### ISH3 – Summary of oral representation made under agenda 3.1 – Landscape and Visual

Sporle with Palgrave Parish Council represented by [REDACTED] - [REDACTED]

DRAWING TITLE:
Interrelationships: the Droves and High Grove - Plan 2

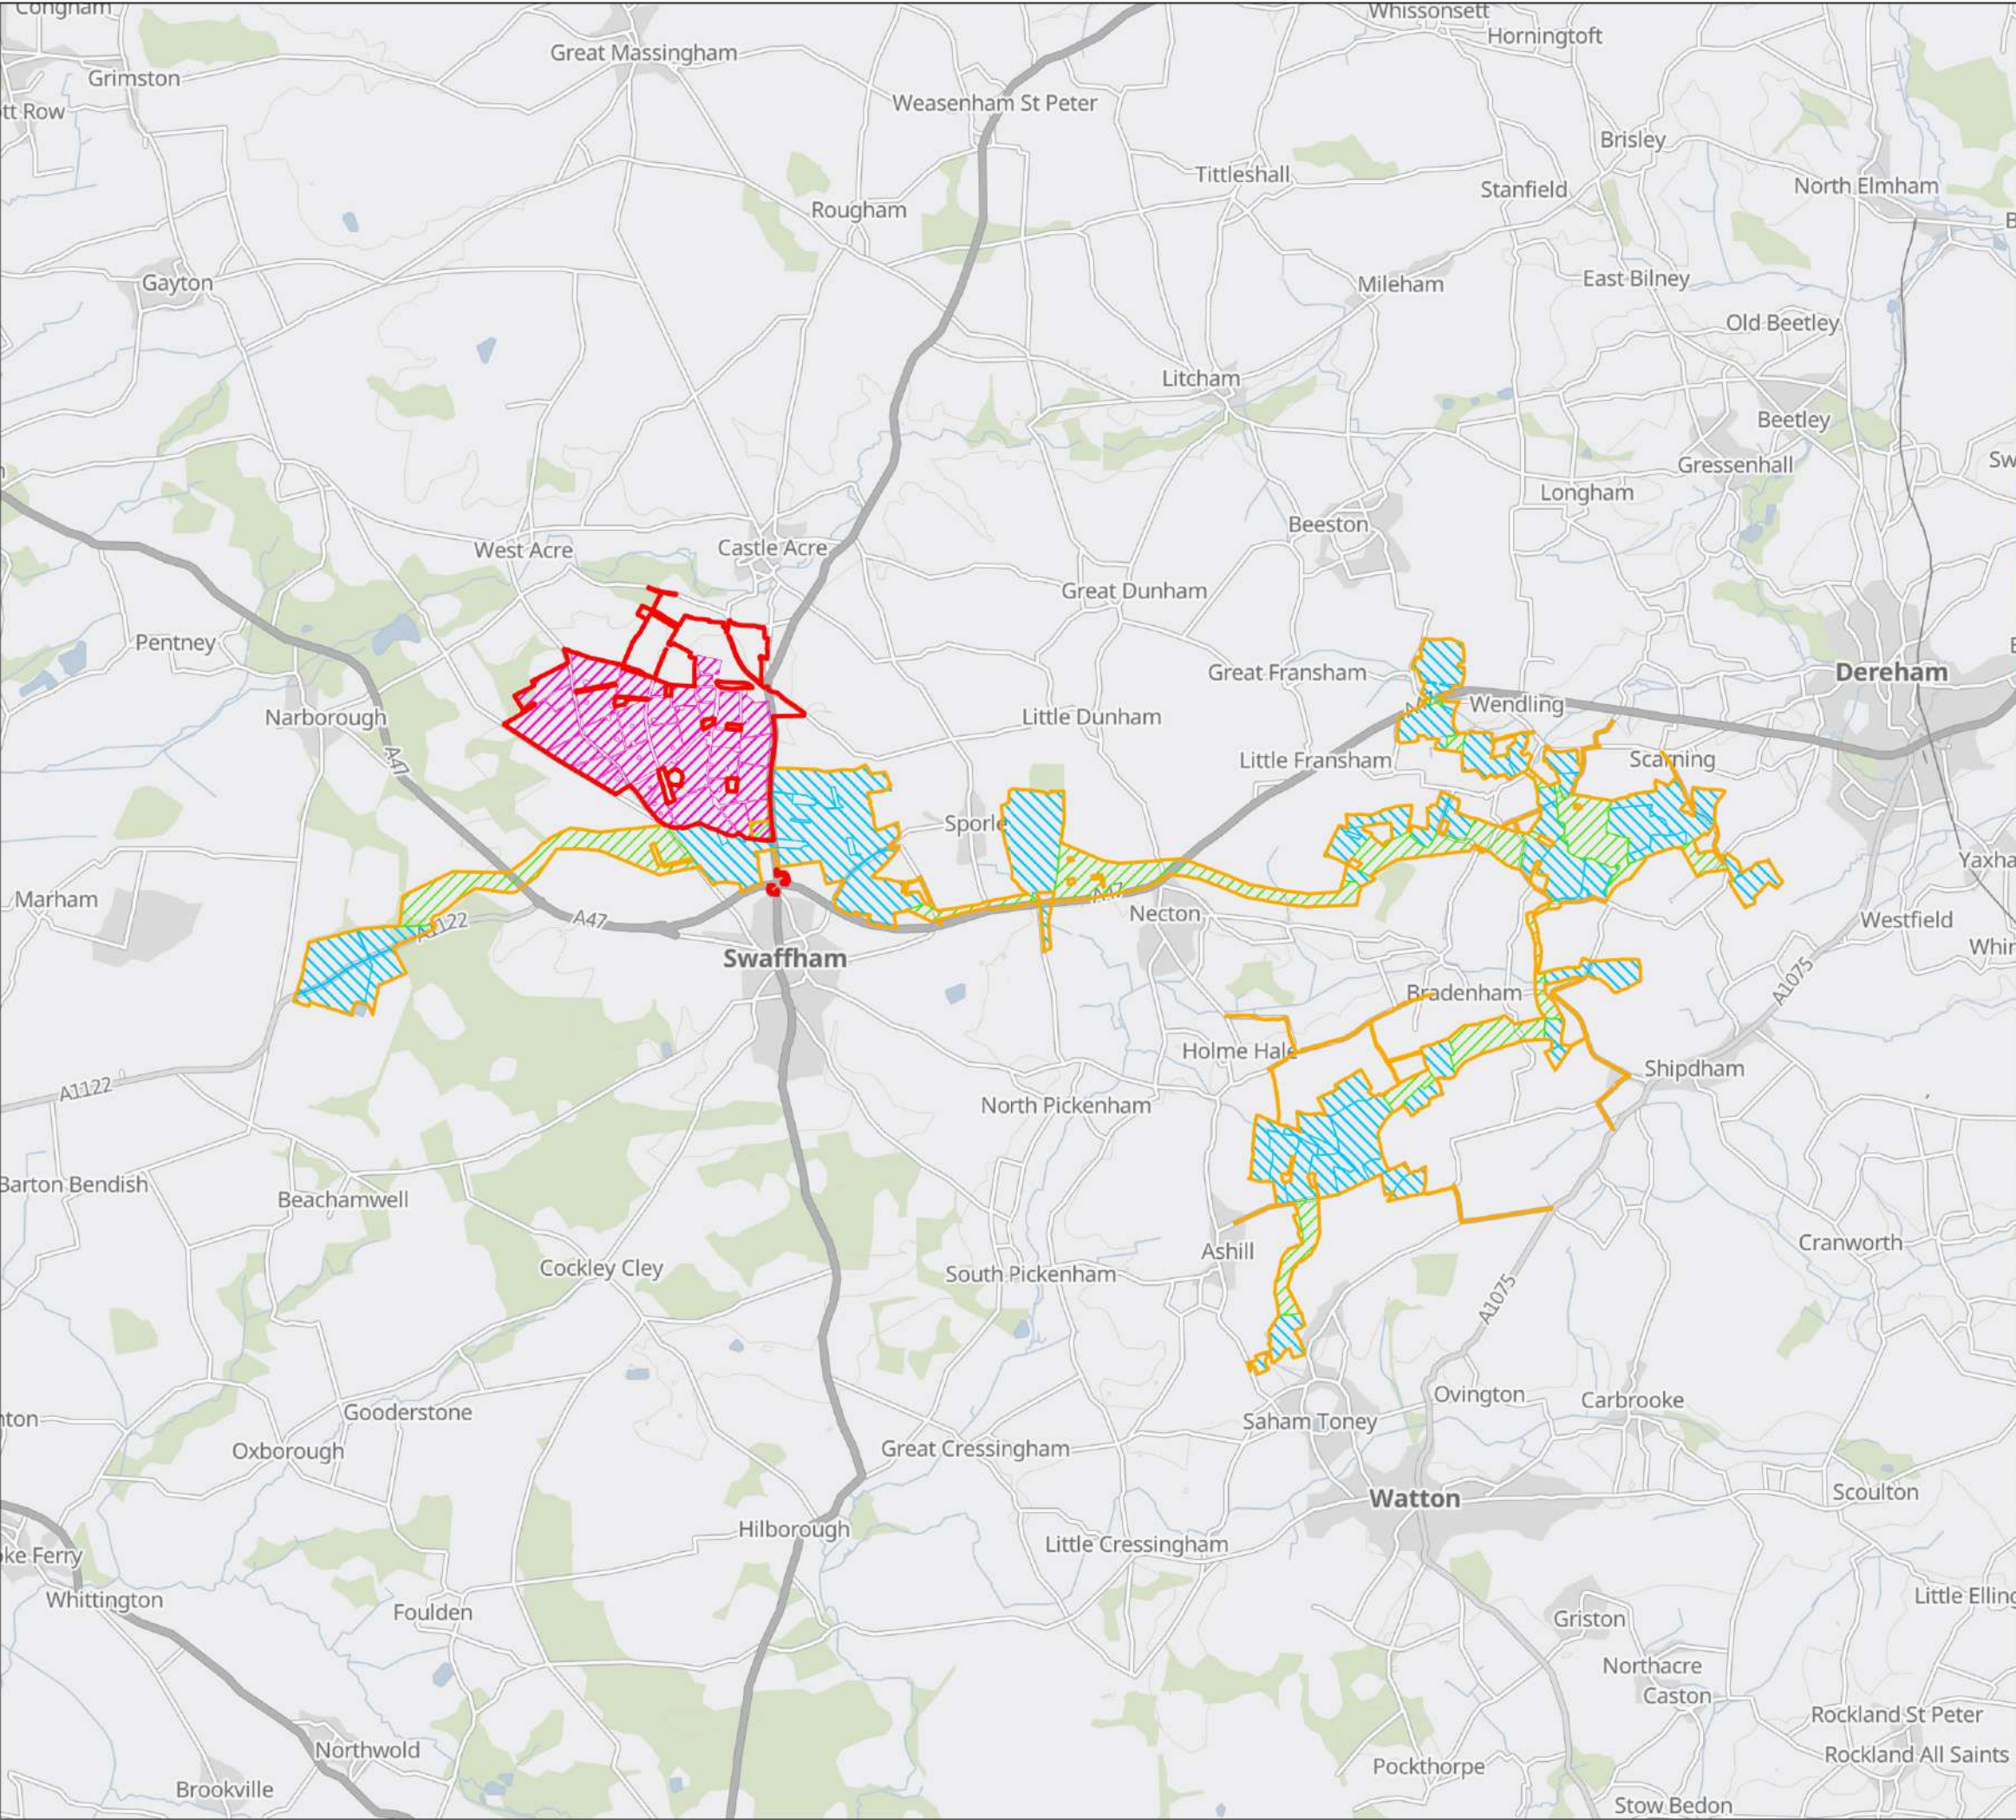
Views from the Peddars Way show 6 fields, three from High Grove and three from Drovers so that, apart from the field closest to the path, the view to Round covert on the horizon is totally of solar arrays apart some break up by the hedges. Sloping ground makes the impact more significant and adverse in our judgement.

We note that section 6.11 of ES chapter 6 Landscape and Visual recognises the cumulative impacts caused by the High Grove development but still concludes its assessment that Visual Receptor Group 4 Great Palgrave and Little Palgrave is only significant and adverse during the construction phase. We would wish to contend that this will be the same for the operational phase of the project and that the ES needs amending to reflect this.

This might be true but the visual impact is still significant and adverse when traversing the view from south round to the southwest. The wireline photographs from Viewpoint 8 (APP-096) only colour the Drovers area and not the High Grove fields as well. As it stands this does not give a true picture of the visual impact. We would suggest that this viewpoint and all other viewpoints shown in the photo montages should include High Grove areas of solar array.

Sporle PC contend that still more work is needed by both projects to reduce the visual impact as we are sure will be seen during ASI1 and hope that continued meetings with the Applicant and High Grove will assist in providing satisfactory solutions.
